DRB Application No.: 09DRB-70100 Project # 1002556
 Project Name: PARADISE HEIGHTS UNIT 1
 Agent: BORDENAVE DESIGNS Phone No.:

Project# 1002556

09DRB-70100 - PRELIMINARY/ FINAL PLAT APPROVAL

BORDENAVE DESIGNS agent(s) for CALABACILLAS GROUP request(s) the above action(s) for all or a portion of Lot(s) 1-7 Block(s) 19, and Tract(s) D & E, **PARADISE HEIGHTS, UNIT 1**, zoned R-1 and C-2, located on the east side of GOLF COURSE RD NW between WESTSIDE BLVD NW and THE BLACK ARROYO containing approximately 18.67 acre(s). (A-12)

PLAT OF TRACTS D-I, E-I &
 AMAFCA BLACK ARROYO CHANNEL
 PARADISE HEIGHTS, UNIT I
 ALBUQUERQUE, NEW MEXICO
 MARCH, 2009

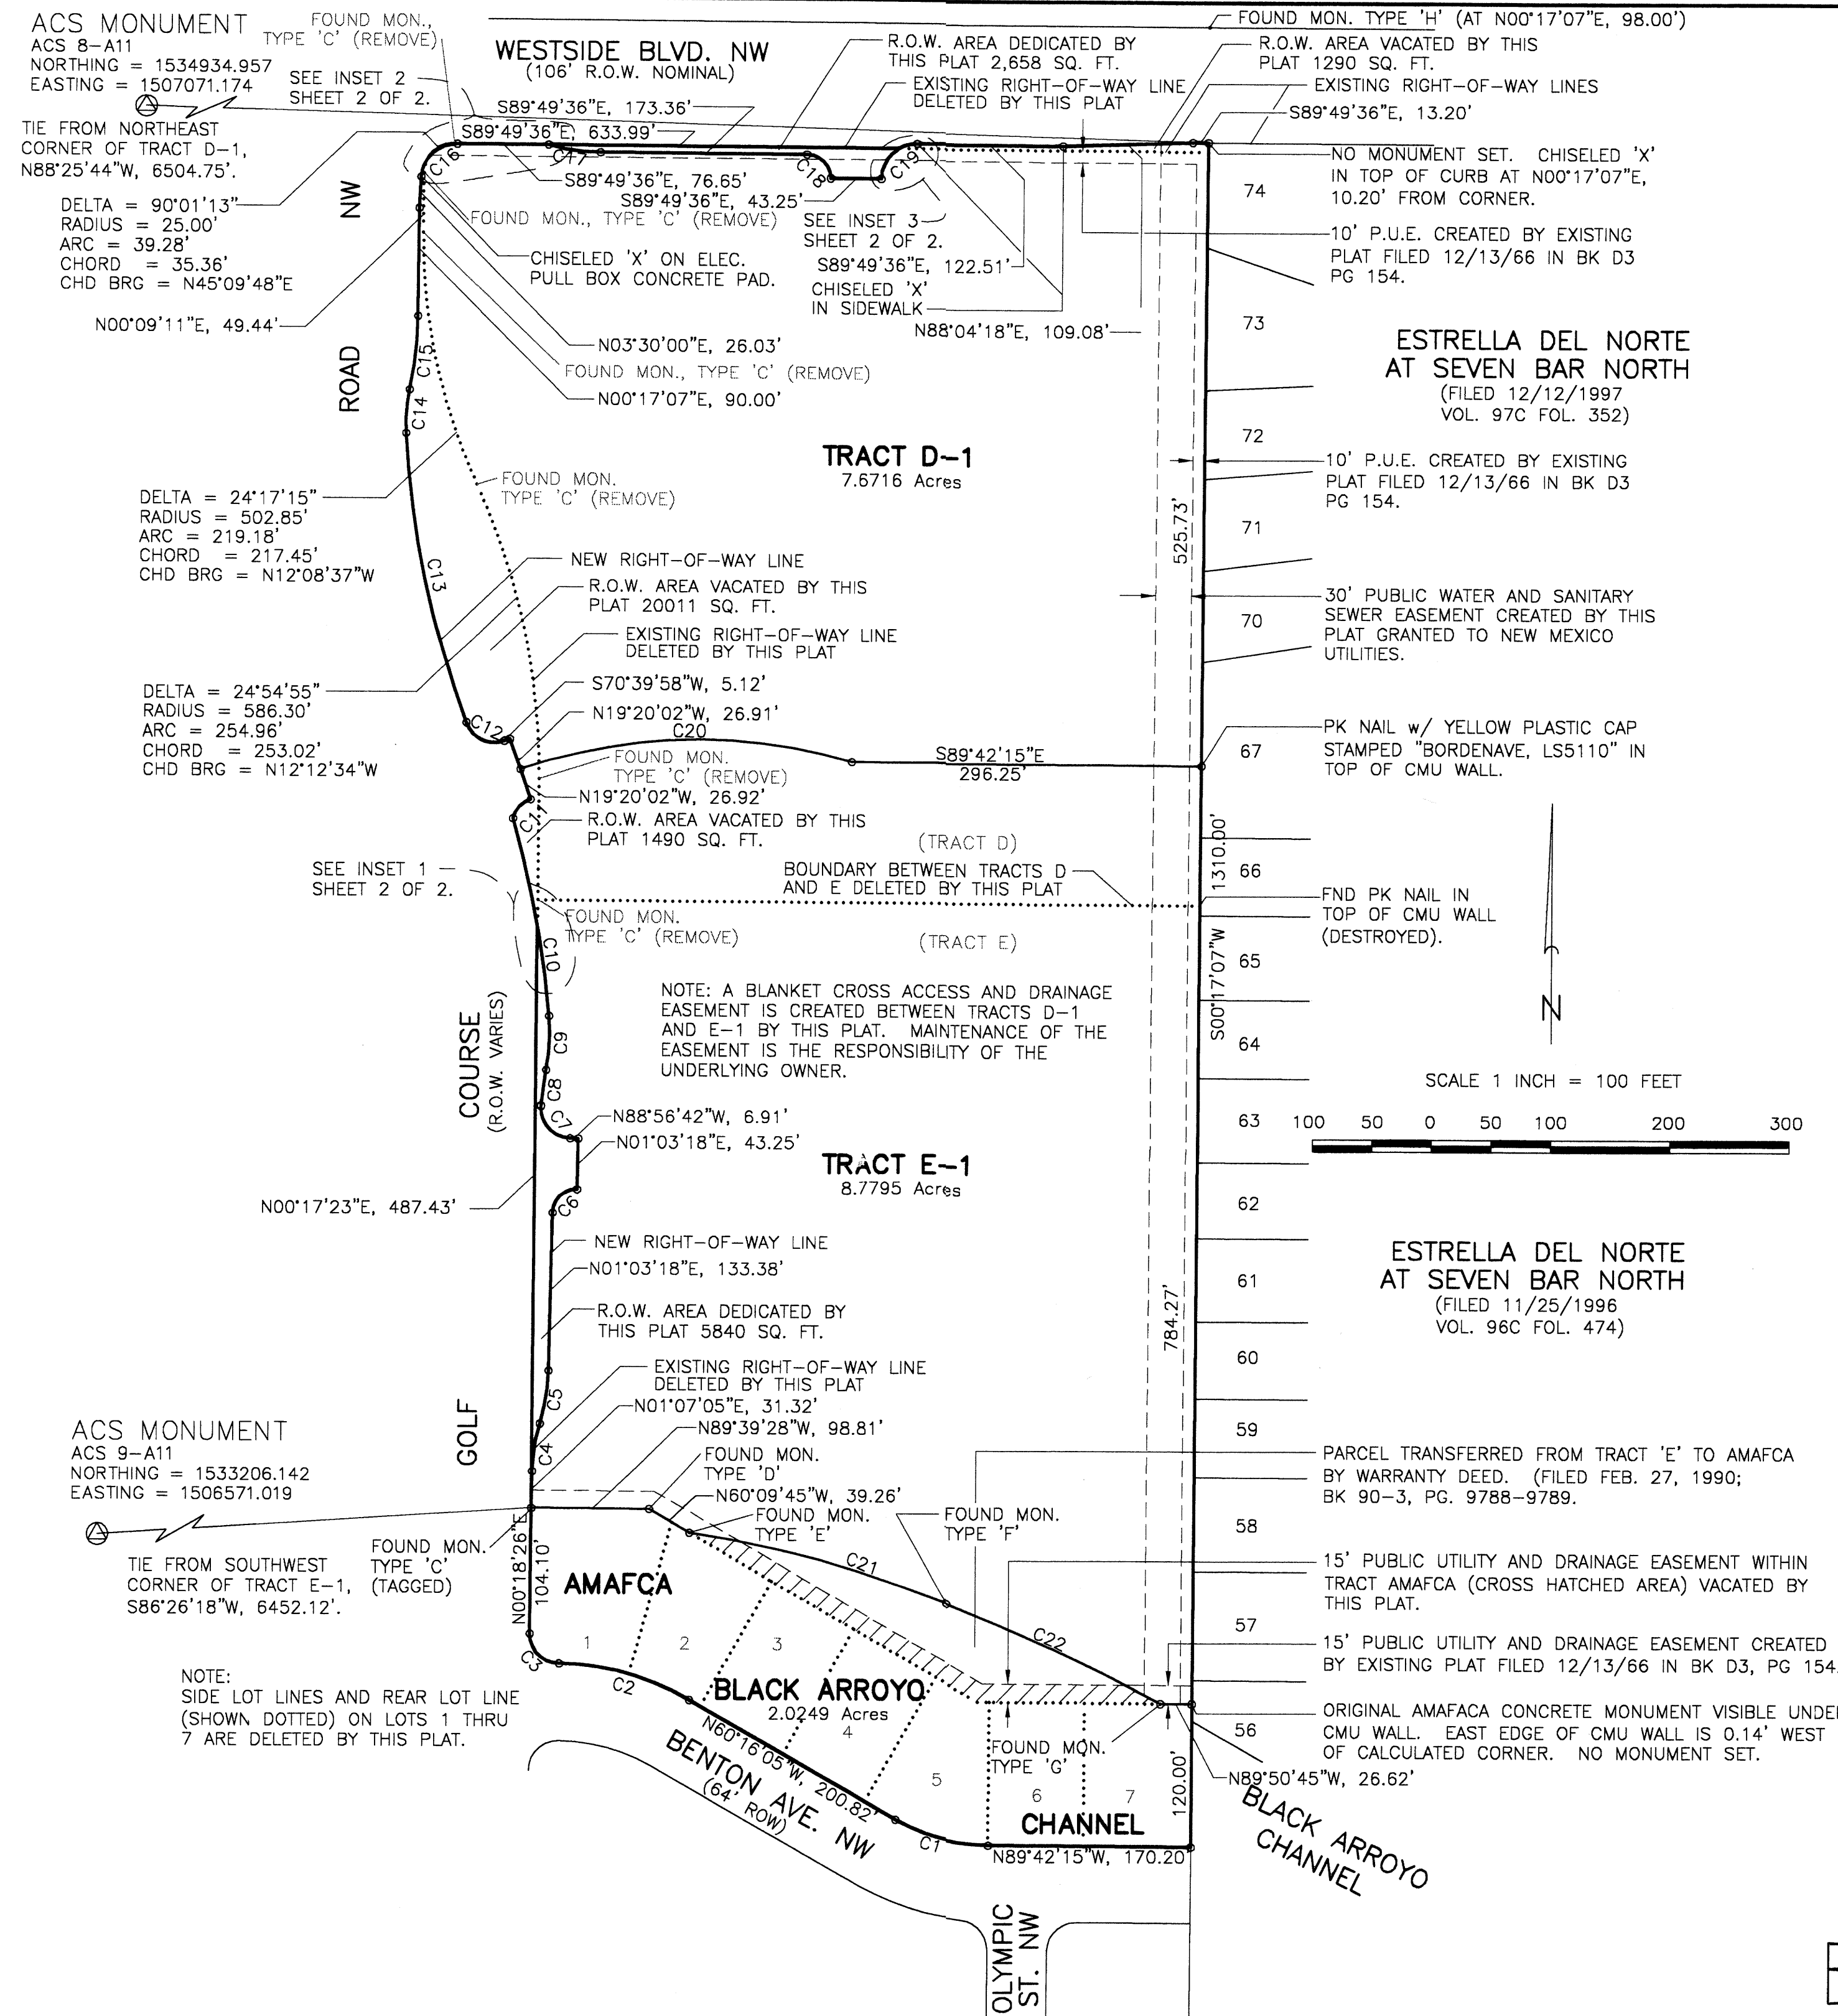
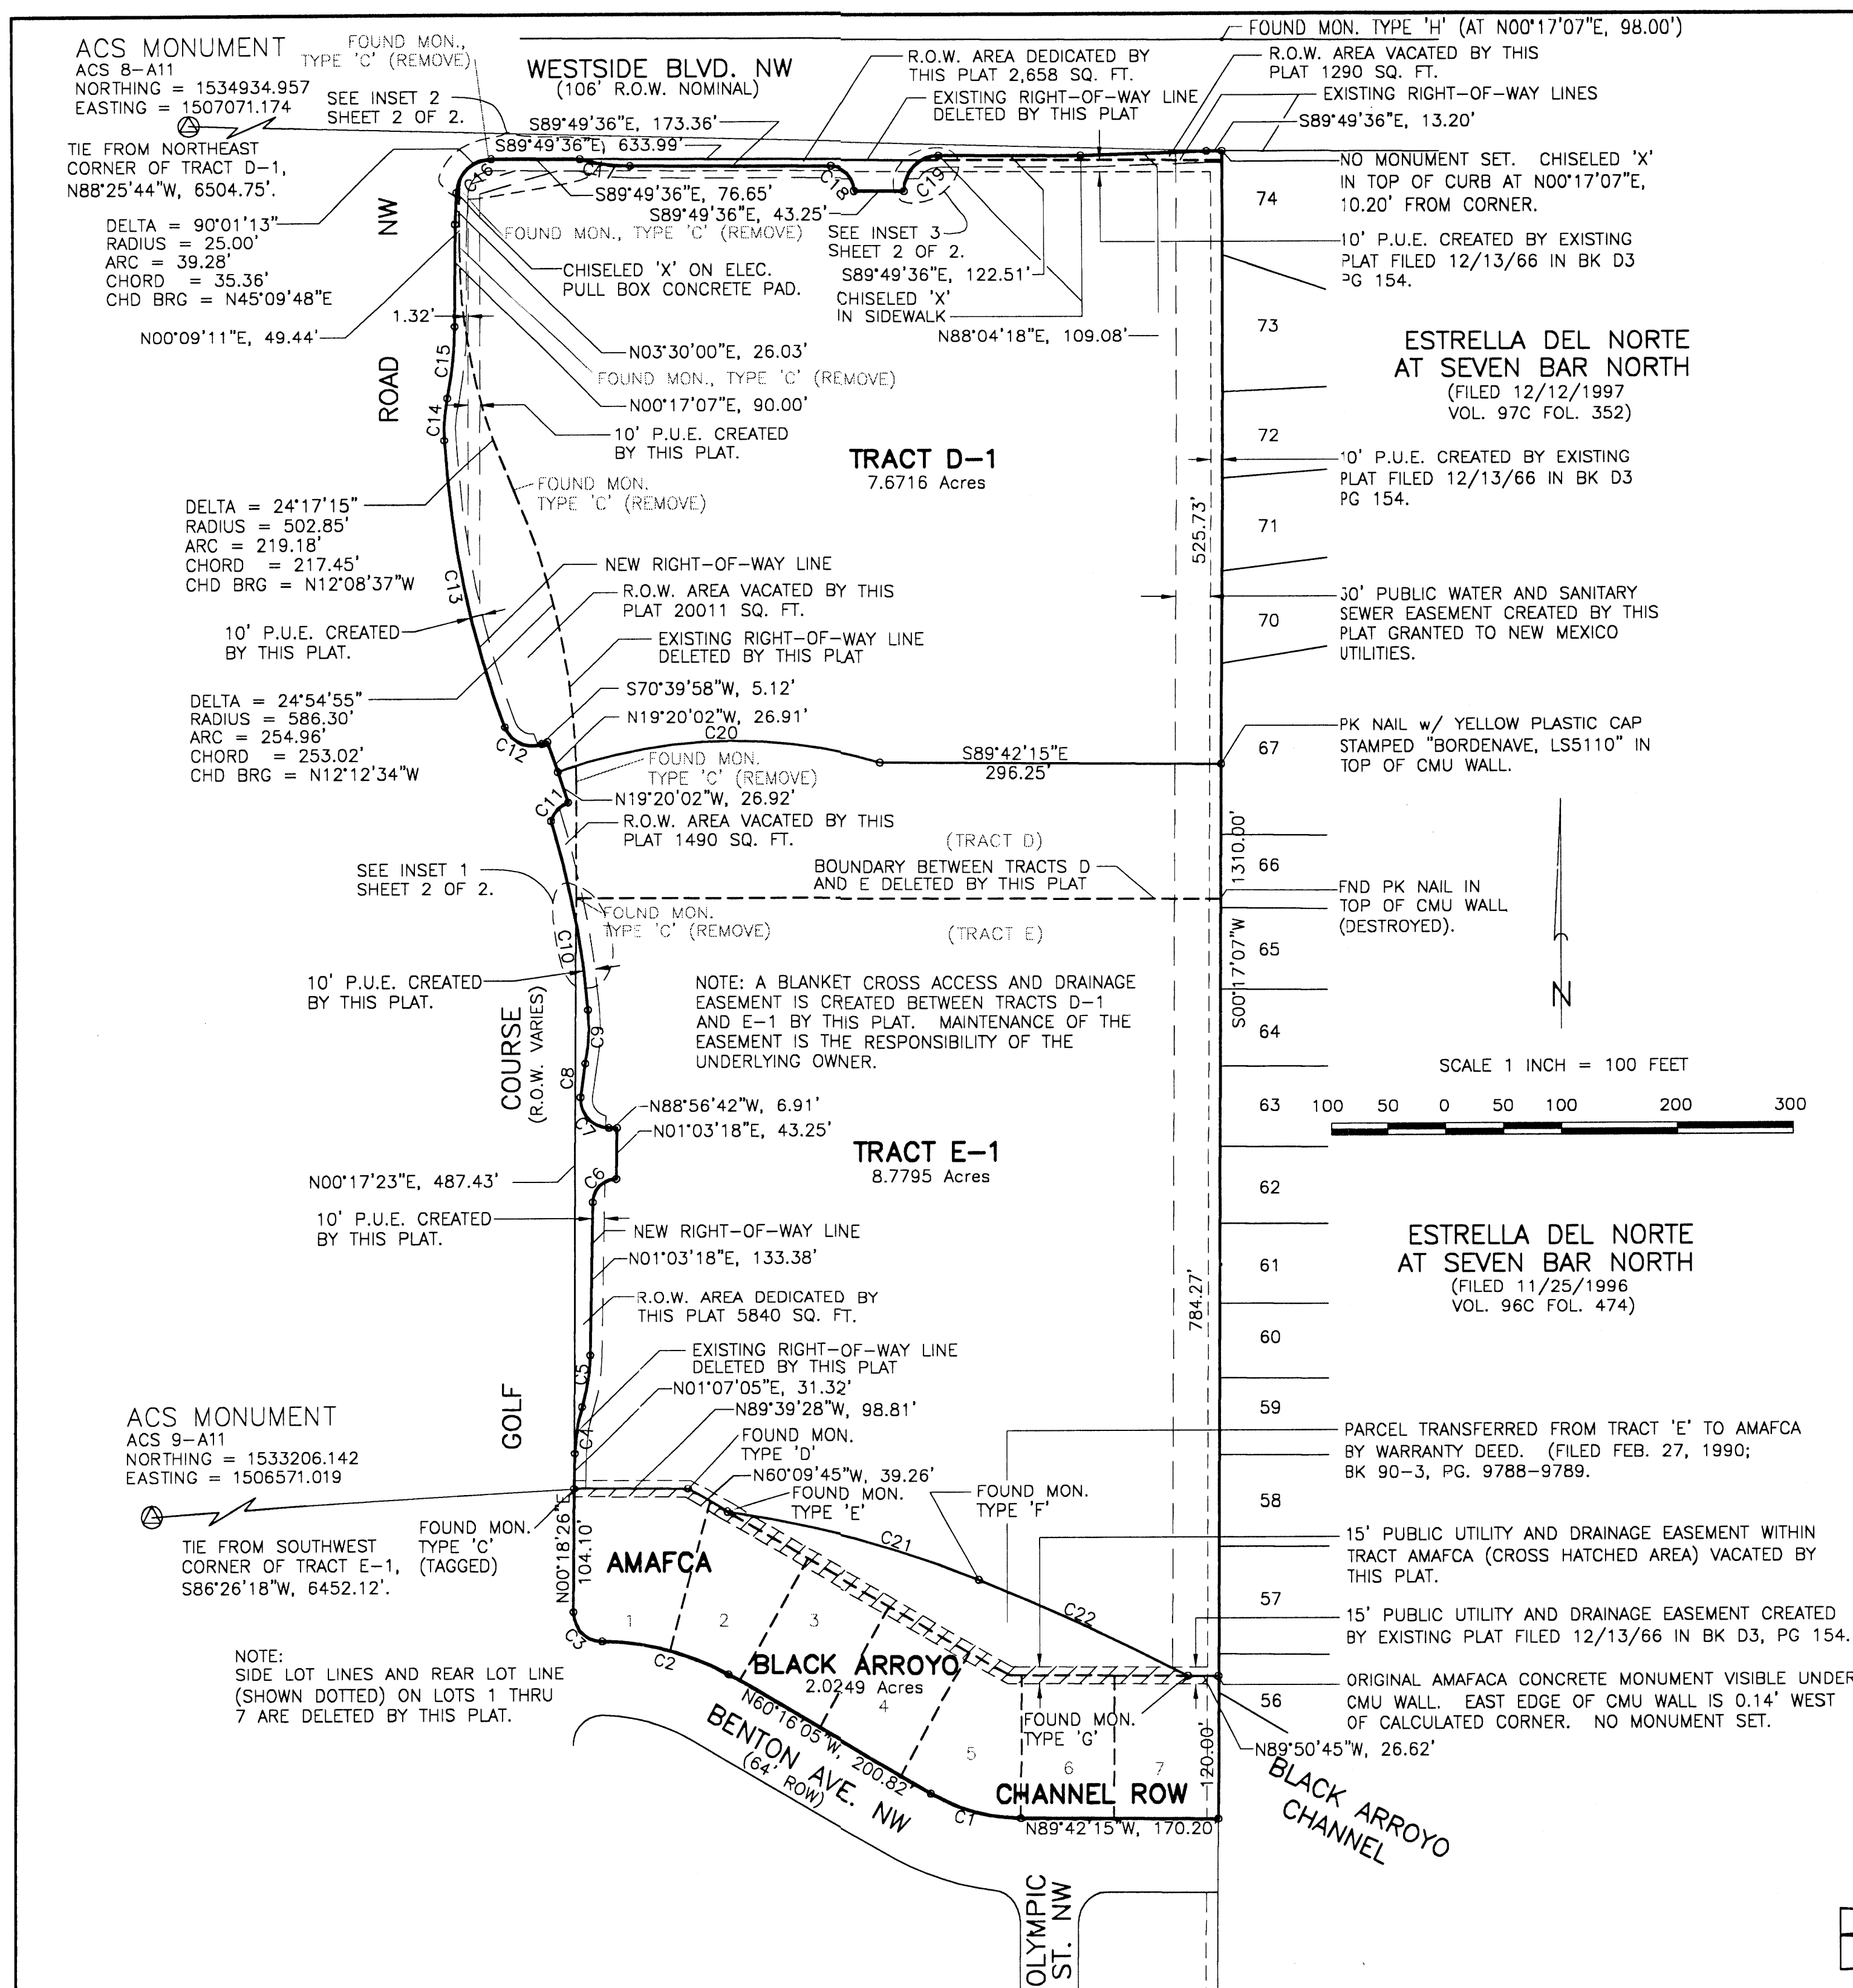
Please ensure there will be pedestrian access to the Black Arroyo Trail from the new commercial development

As discussed on June 4, 2008, verification of the distance from face of curb to the property line along the vacated area is required prior to approval.

Provide an exhibit showing the location of sidewalk and defining the distance from face of curb to the property line. Right of way dedication may be required.

Refer to comments from affected agencies/ divisions regarding proposed Bulk Land Variance. Status of the site development plan and AMAFCA property need to be clarified, i.e. whether it is right-of-way.
